EPC STORMWATER REVIEW COMMENTS ARE SHOWN IN ORANGE BOXES WITH BLACK TEXT

# PAINT BRUSH HILLS METROPOLITAN DISTRICT SCENIC VIEW AT PAINT BRUSH HILLS POND MODIFICATIONS

SCENIC VIEW AT PAINT BRUSH HILLS POND MODIFICATIONS, RGA PROJECT NO. 1070.0022

SCENIC VIEW AT PAINT BRUSH HILLS DETENTION POND MODIFICATIONS
NOTES
DRAWN BY: JCS
DESIGNED BY: GEW
JOB NUMBER: 1070.0022
DATE: 8/23/22
SCALE: N.T.S.
DRAWING NAME: NOTES
SHEET NO: 2 of 8

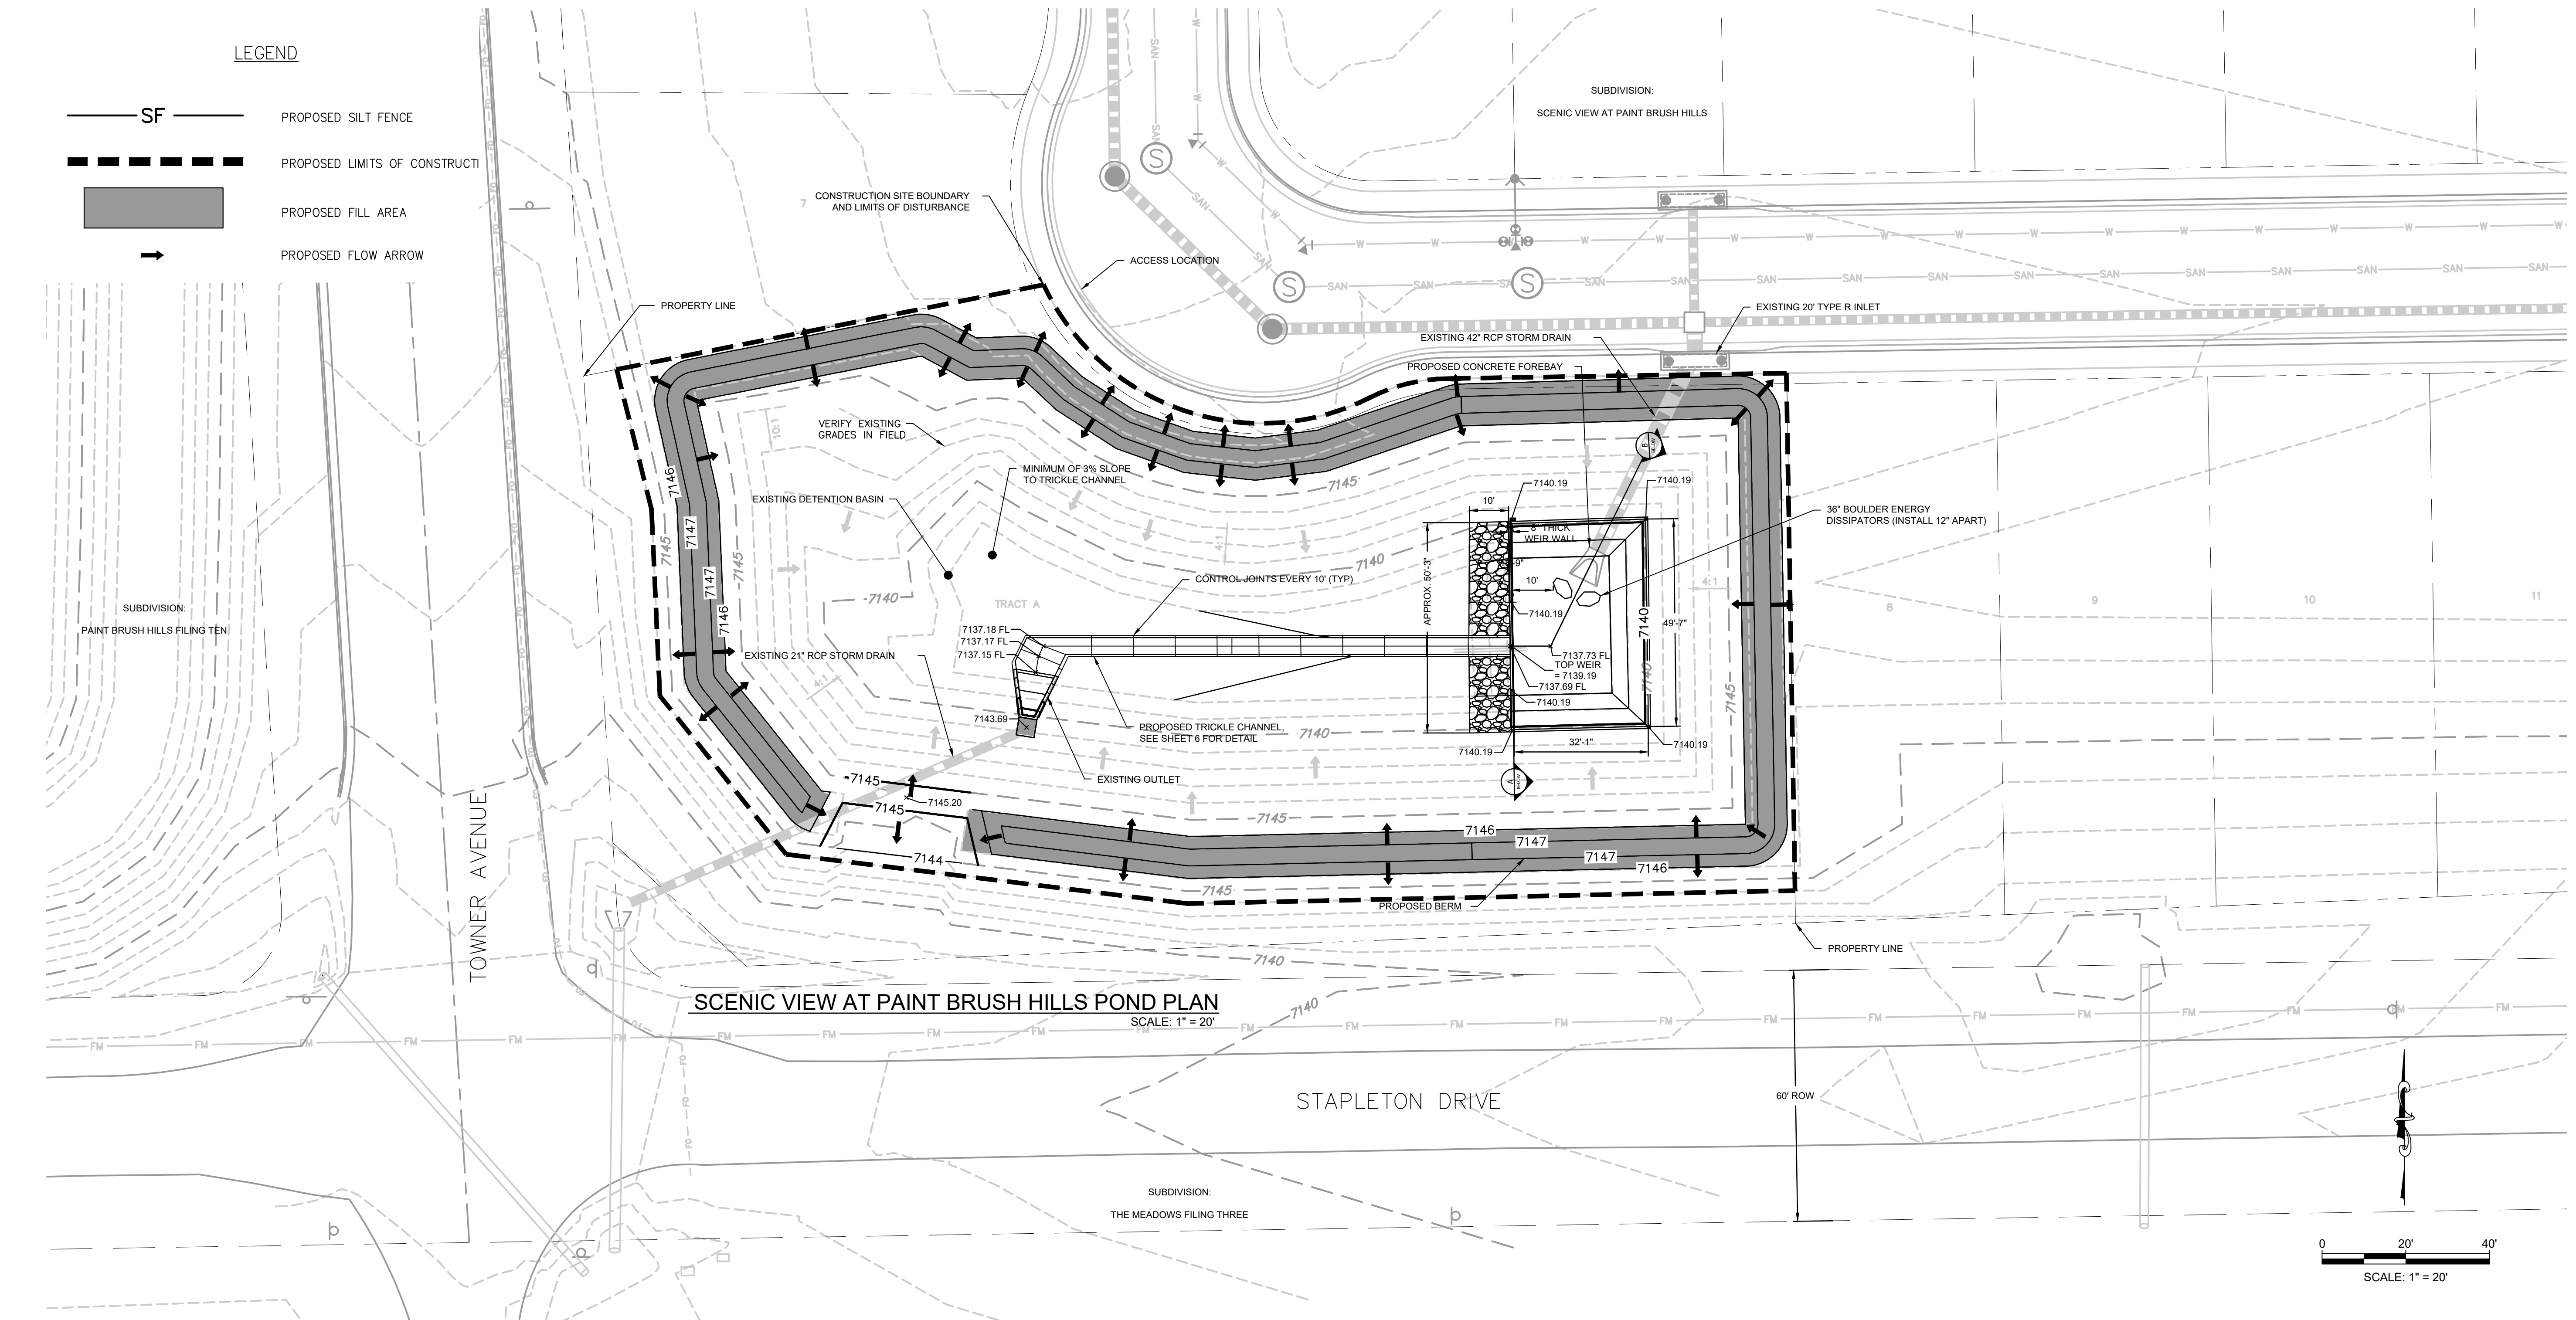
To comply with the SWMP Checklist Item 17f, please add a note stating no batch plants will be utilized onsite.  
 Add a note about existing vegetation

Update to include the entire EPC Construction notes. See document.

**SCENIC VIEW AT PAINT BRUSH HILLS POND PLAN**  
SCALE: 1" = 20'

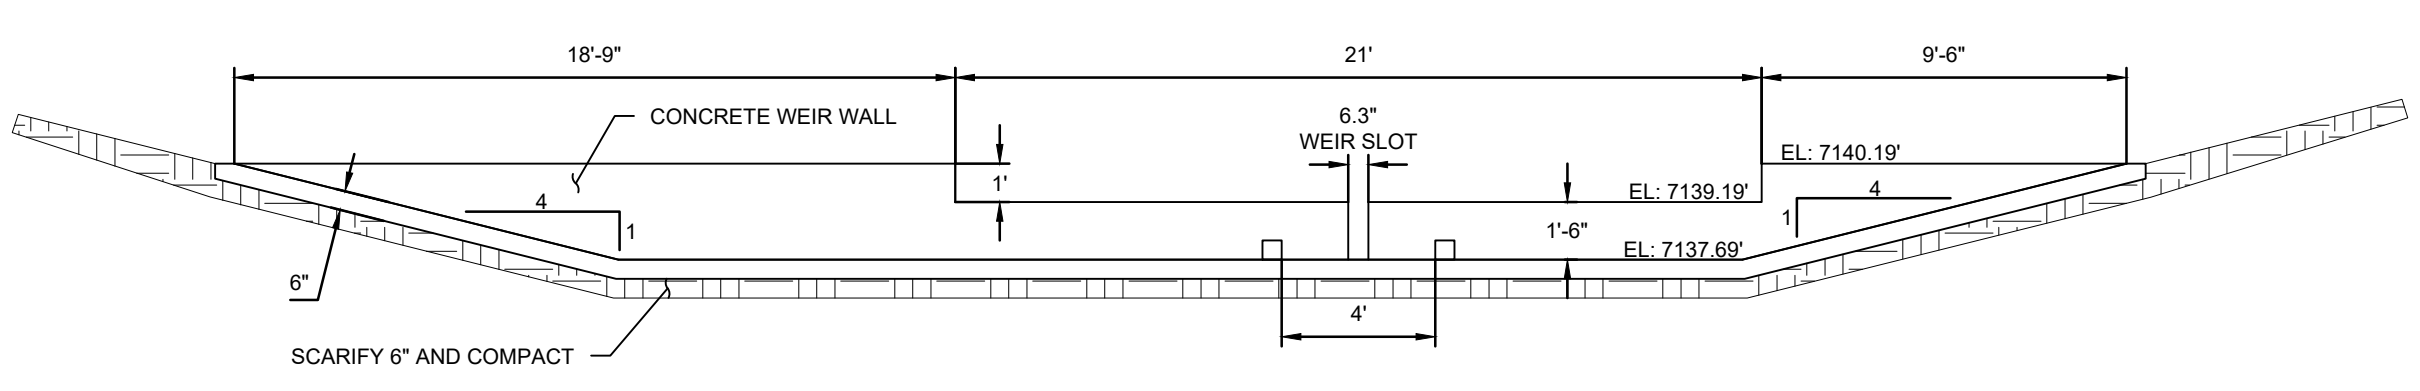
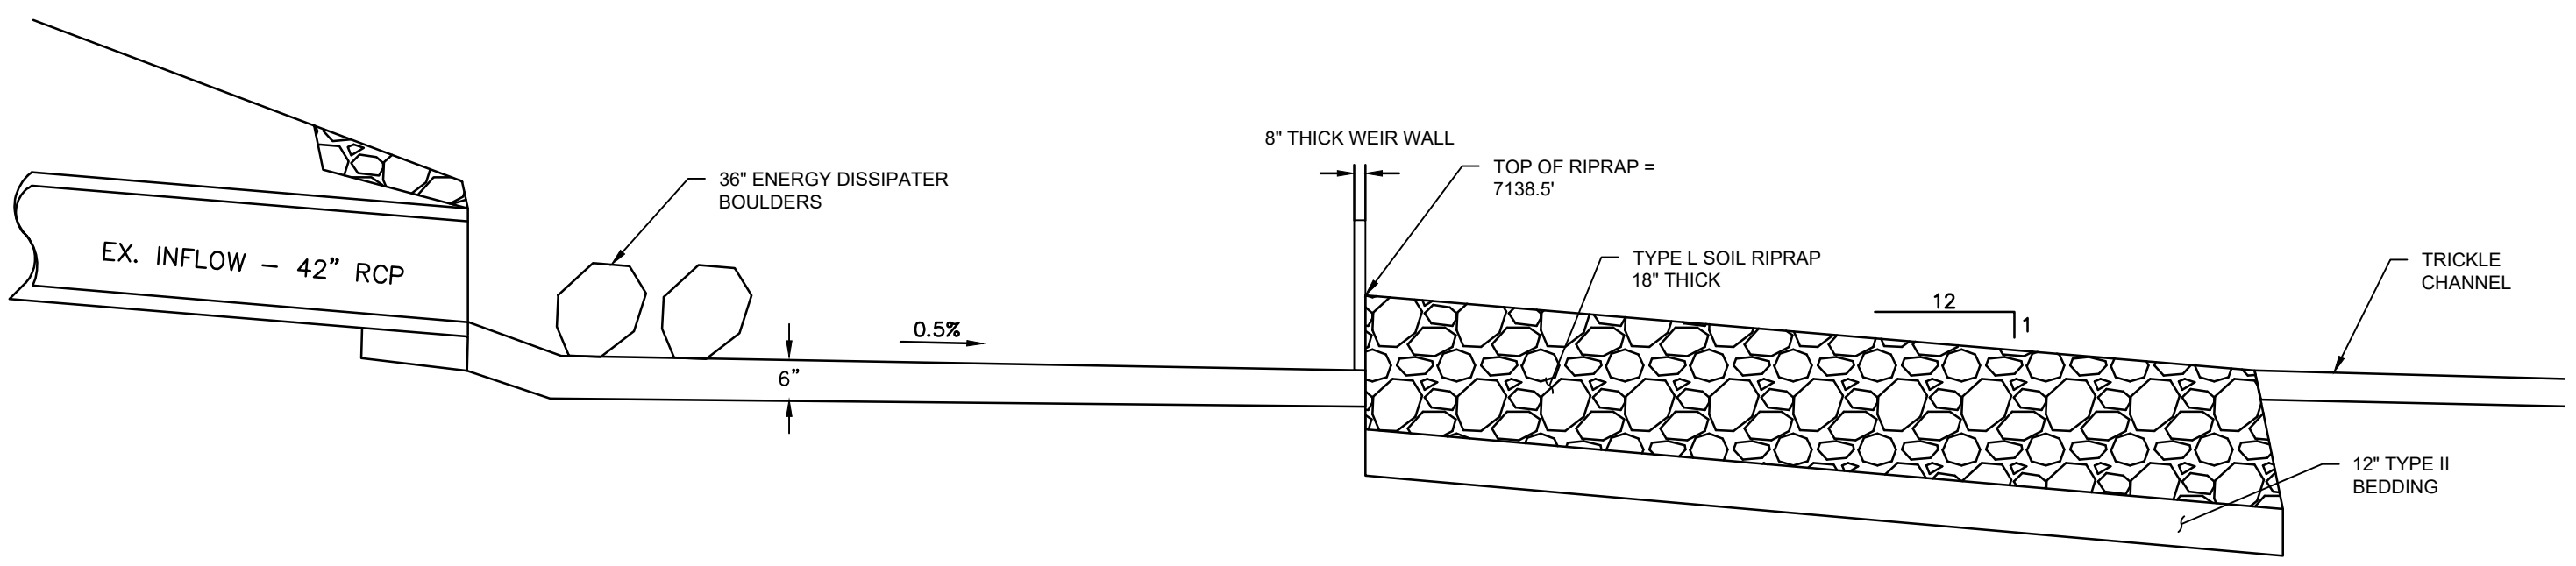
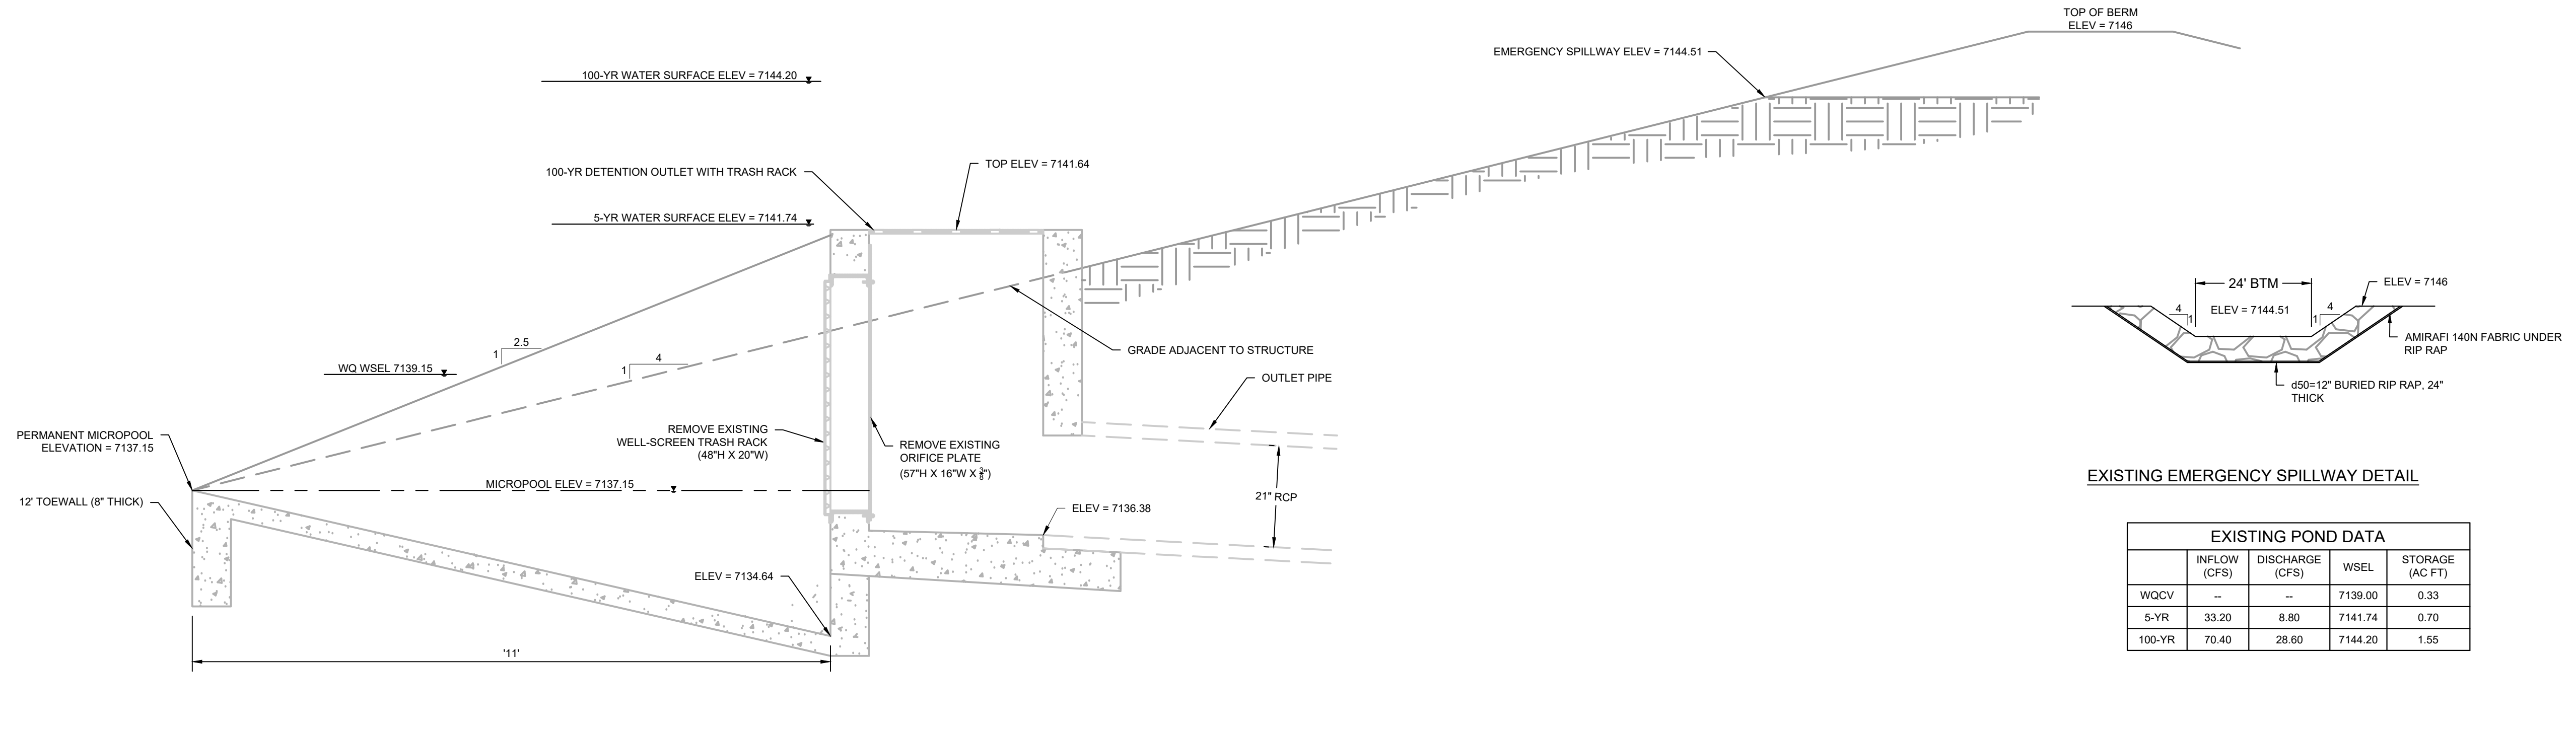
add property lines to legend or call out on figure  
 add all existing and proposed easements  
 show construction site boundary  
 show limits of disturbance  
 note: If "limits of disturbance" and "construction boundary" are the same, you can use one line type and label it "limits of construction/disturbance" or otherwise show as separate line types for each on the legend and figure.  
 Show areas of cut/fill  
 Show stormwater flow arrows

Label adjacent subdivision name

Label subdivision name

Label adjacent subdivision name, and property parcel numbers
